**Re: Application by Vattenfall Wind Power Limited for an Order Granting
Development Consent for the Thanet Extension Offshore Wind Farm –
Response to Examining Authorities First Written Questions.**

Following the Planning Inspectorate's Rule 8 letter, dated 18 December 2018, Kent County Council (KCC) submits its response to the First Written Questions.

Figure 4.5 Cross Section of above ground TJB

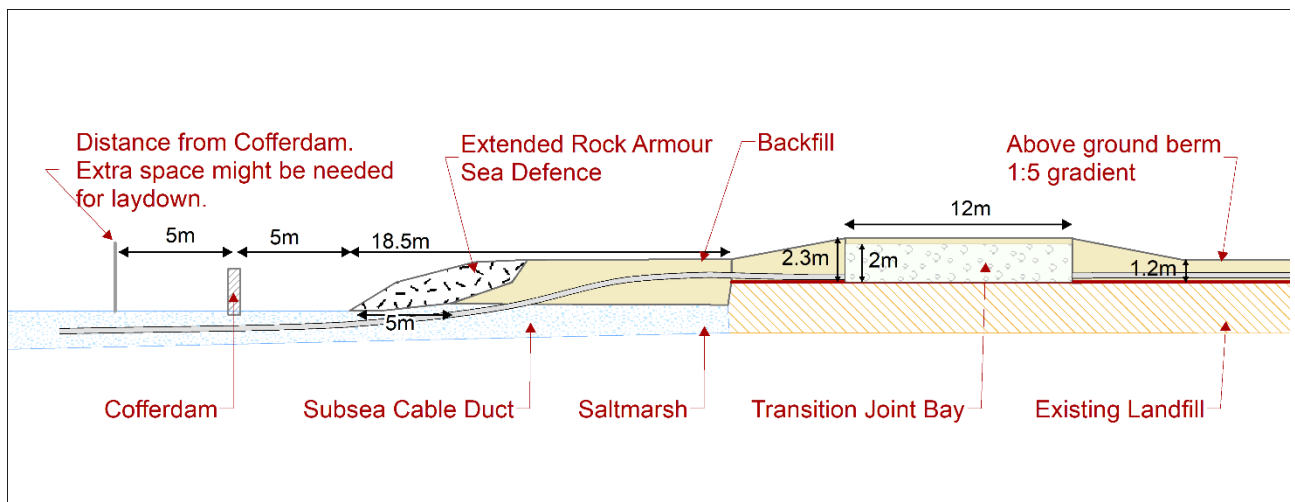
a) KCC's preference is for the Transition Joint Bay (TJB) to be underground, as this will reduce the impact on access and recreation in the Park. If the TJB is sited overground, this will adversely affect the flat coastal path. Under Option 1, the sea wall would be kept as it currently is. Under Option 3 (trenching), if the England Coast Path (ECP) is temporarily diverted, KCC would like to see the entire section of the coast path upgraded within the Country Park, as the construction work is carried out. The position of the TJB within the Red Line Boundary (RLB) needs to be agreed with KCC and sited away from the busy crossroads area of the internal path structure. This would not only reduce disruption to walkers, but also reduce the need to reinstate the public walkway.
